Application No: A/39/25/HH
Site Address: Field House The Thatchway Angmering BN16 4HJ
Description of works: Erection of two storey side extension.

Thank you for your internet representation made on 28th March 2025 which has been recorded as an objection with the comments as follows:

PRIVACY SCREEN DETAIL 1/50

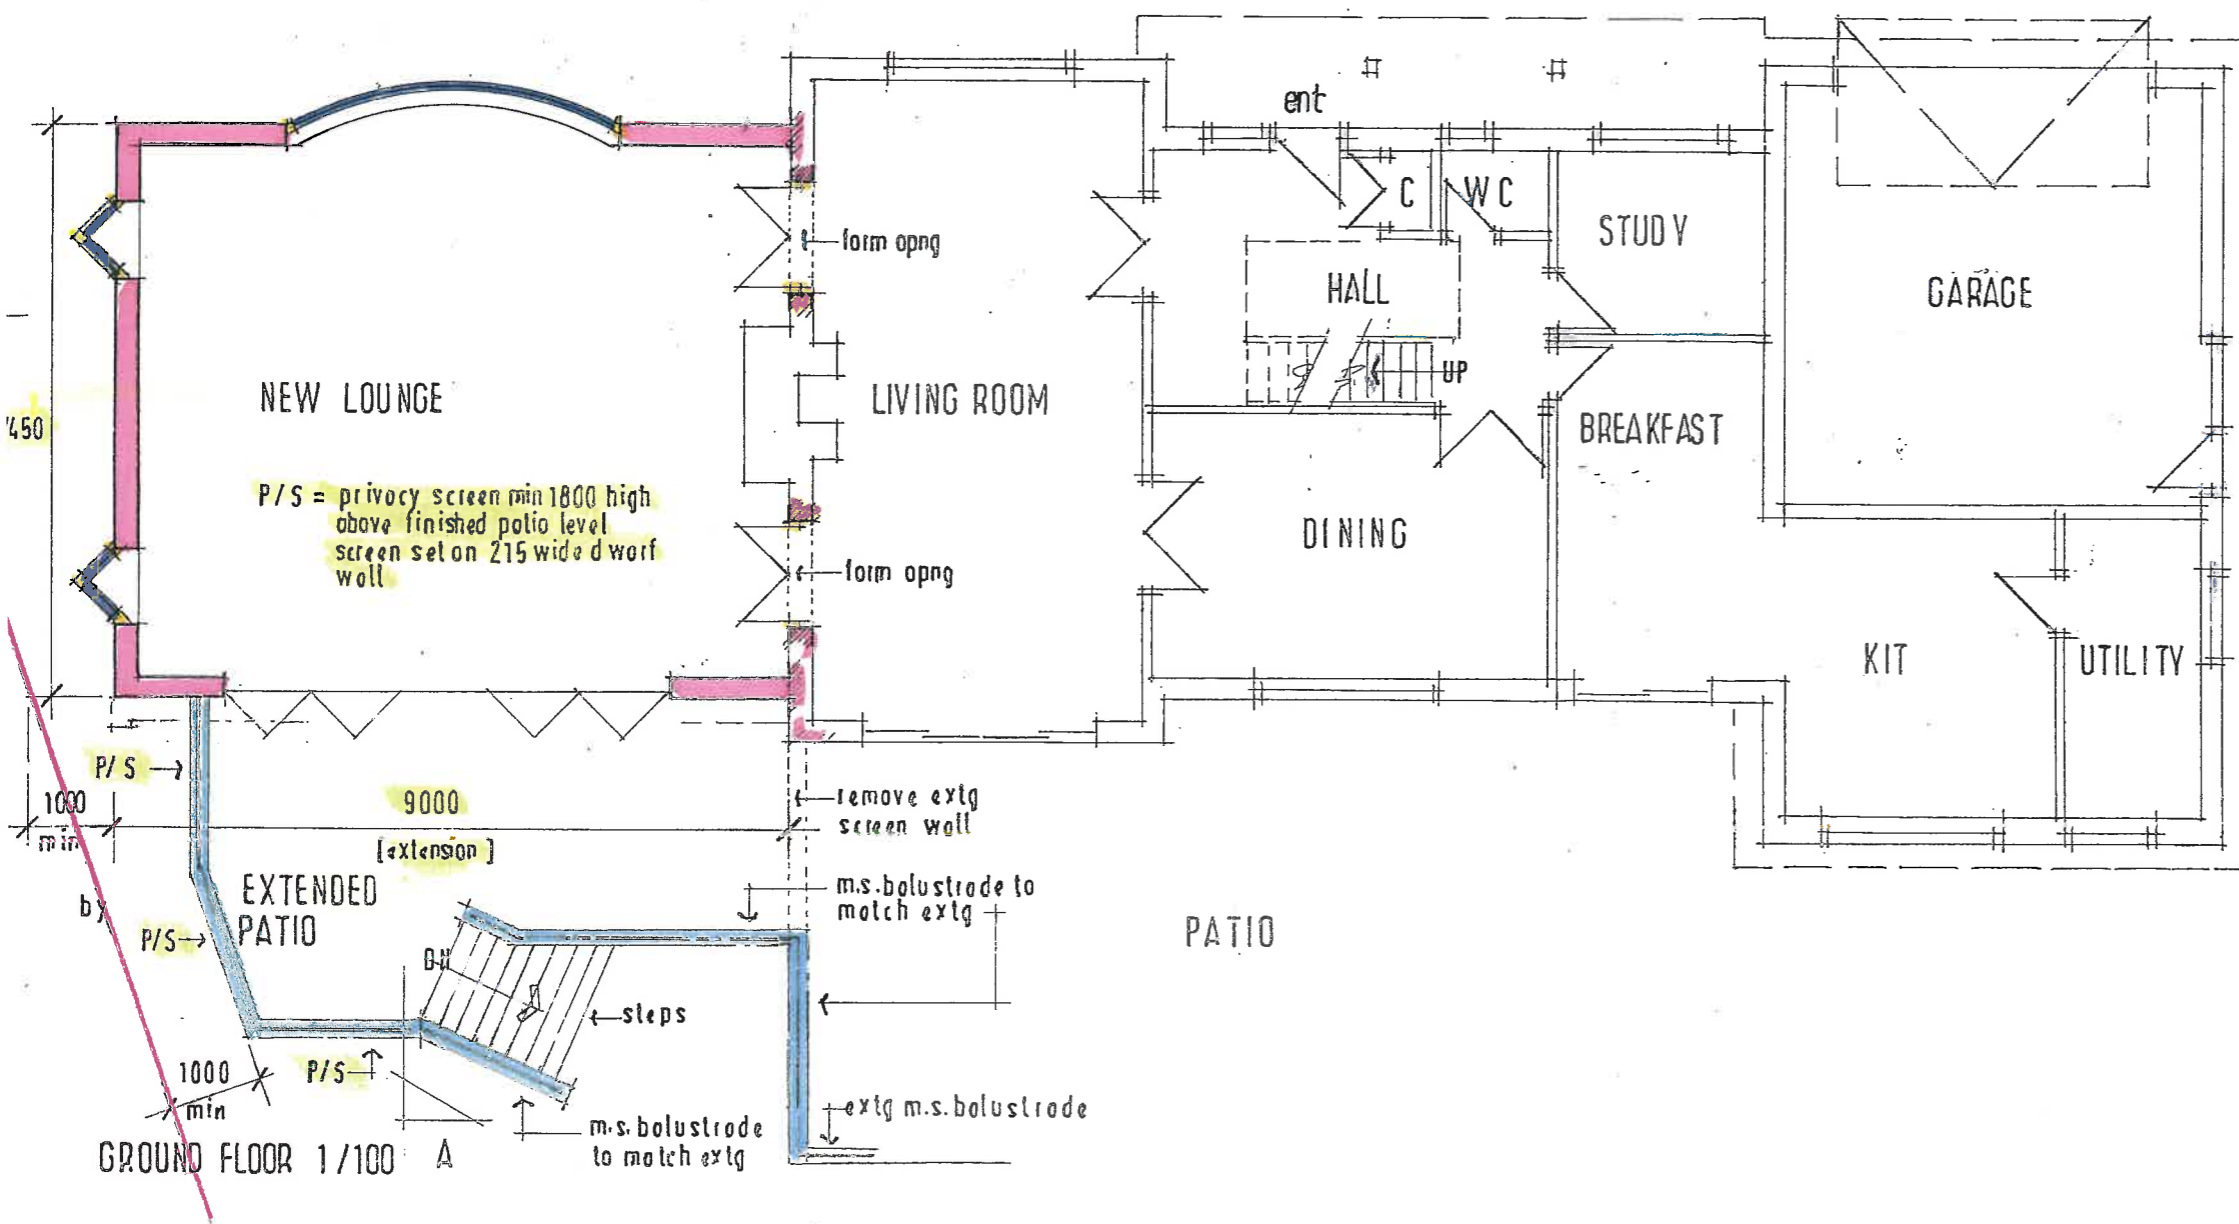
This extension comes very close to my boundary and will overlook my property. I note the provision of a privacy screen included for the first application to get passed. However the property will still be too close and look like a large infill. I will lose light through my side window. In my deeds there is a Covenant that states that I must provide a hedge to act as a screen between the two properties. The proposed new extension will be very close to this hedge and will impede its' growth. I need access to maintain this hedge to legally fulfil the Covenant. There needs to be sufficient space to allow a hedge cutting platform to be used.
